Our Reference: DOC18/126455
Your Ref. SSD 8900

Nulon Motor Oils Facility, Bringelly Road Business Hub (SSD 8900)

The NSW Environment Protection Authority ("EPA") acknowledge the NSW Department of Planning and Environment's ("DPE") request for comment on the proposed development of the Nulon Motor Oils Warehouse.

The EPA has reviewed the document titled Environment Impact Statement ("EIS") prepared by Ethos Urban and dated 18 January 2018. Based on the information provided, the EPA is unable to complete a full assessment of this application.

AUTOMATIC POLLUTION ISOLATION VALVE (PIV) DETAILS -PIT A14 & PIT B16

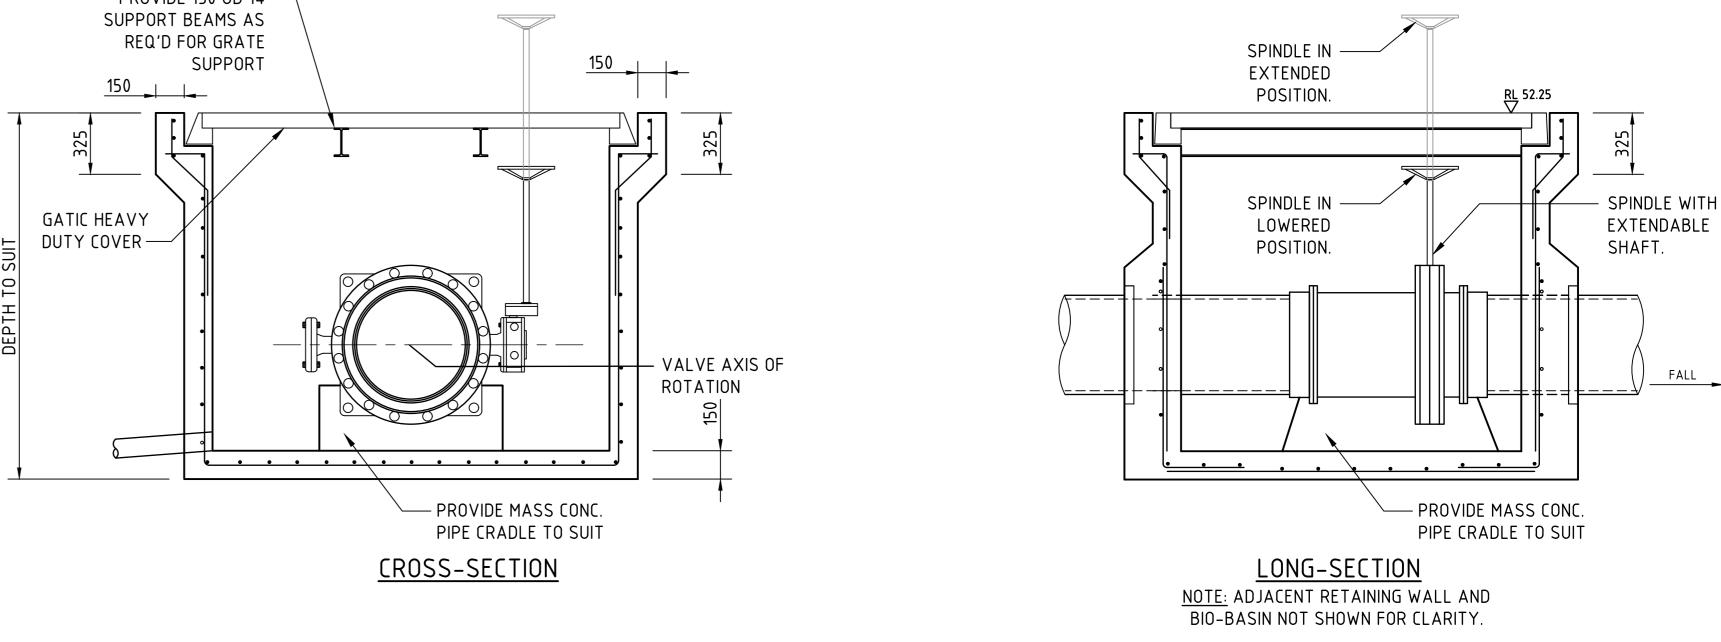
The EIS describes a storm-water isolation valve or containment valve. The Proponent is required to nominate the expected amount of firewater containment capacity available on the premises.
